City of Albuquerque

HYDROLOGY SECTION
123 Central NW, Albuquerque, NM 87102
(505) 766-7644

October 27, 1986

RE: CONCEPTUAL GRADING & DRAINAGE PLAN SUBMITTAL OF SIGMA CHI
FOUR PLEX RECEIVED OCTOBER 10, 1986 FOR SITE DEVELOPMENT
PLAT APPROVAL (J-15/D30)

CONCEPTUAL DRAINAGE PLAN

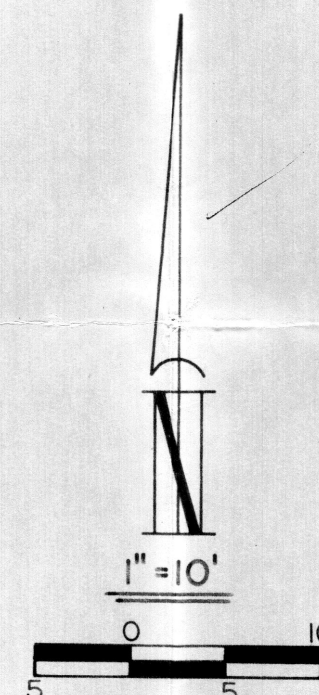
Since the rear yard pond is closer than 15 feet to the property line
and adjacent structures, an impermeable pond liner or equivalent will
be required to contain all runoff within the property with no seepage
allowed through the CMU wall or under it.

A more detailed Drainage Plan will be required before Building Permit
sign-off by Hydrology.
